Howerton Services, PLLC
License # P-1716
3513 Cathedral Bell Road
Raleigh, NC 27614
(919) 270-3460

November 15, 2023

Subject: 32 Dauphine Street
Fuquay Varina, NC 27526
Plan Revision Letter
Harnett County Permit #: SFD2308-0046

2 STORY FOUNDATION DETAILS (OPTIONS)

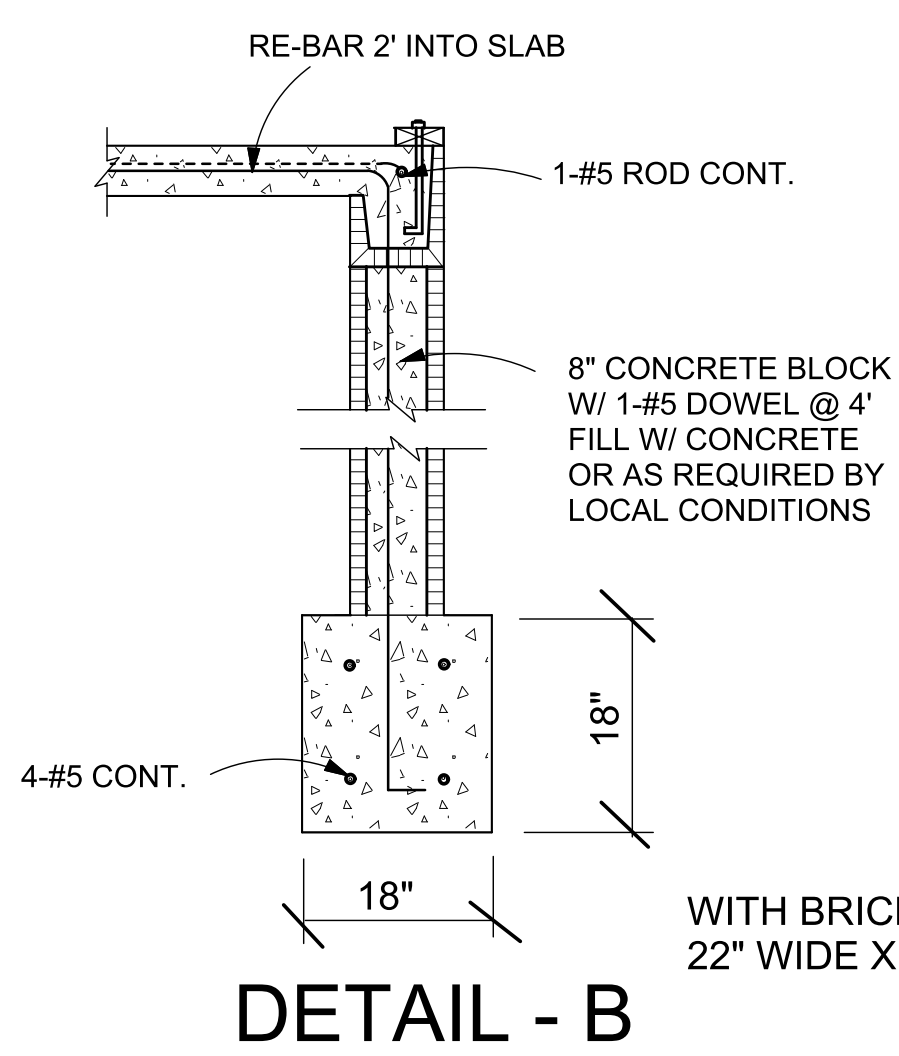
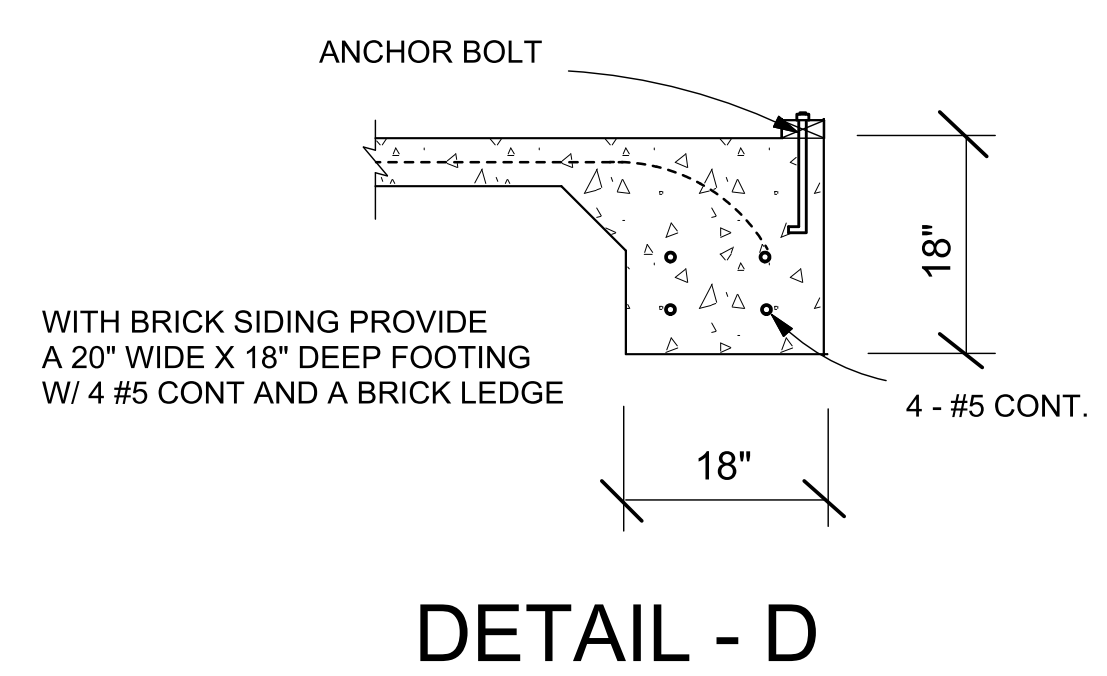
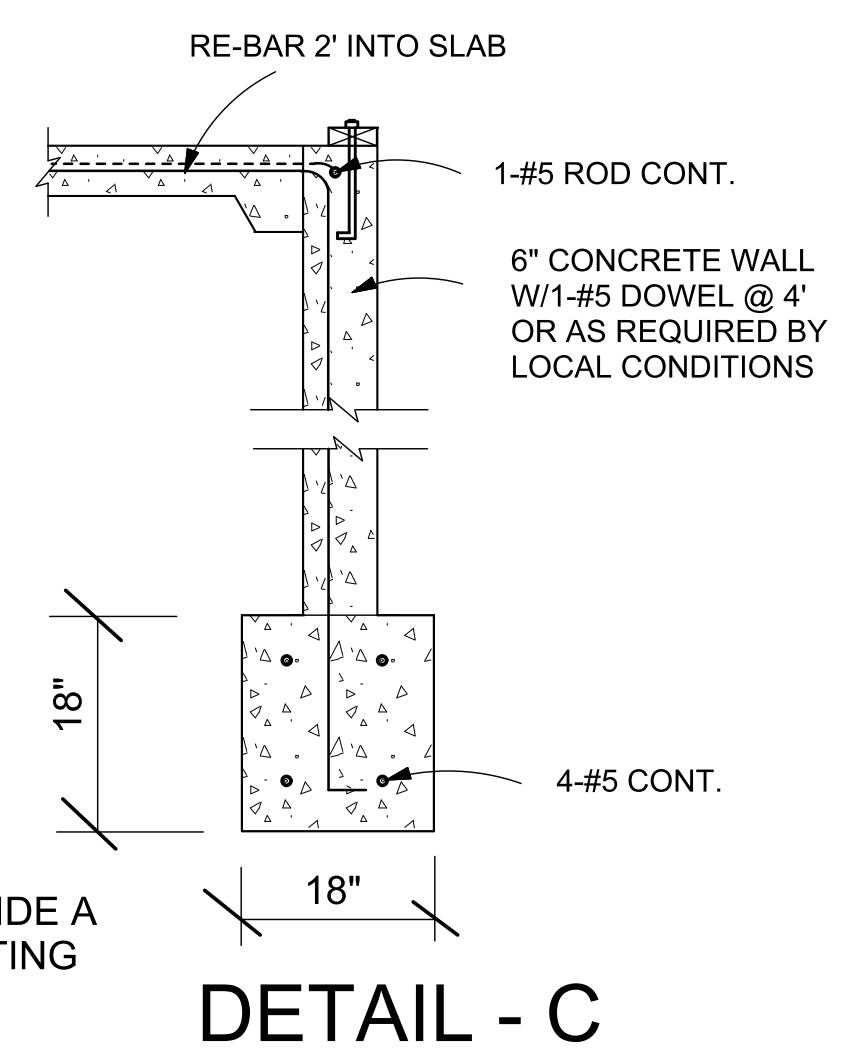
- Item 1 – The continuous footings for this project will be modified. The new continuous footings will be 20”x 10” with 2 - #4 bars continuous. All other footings shown in the plans will remain the same.
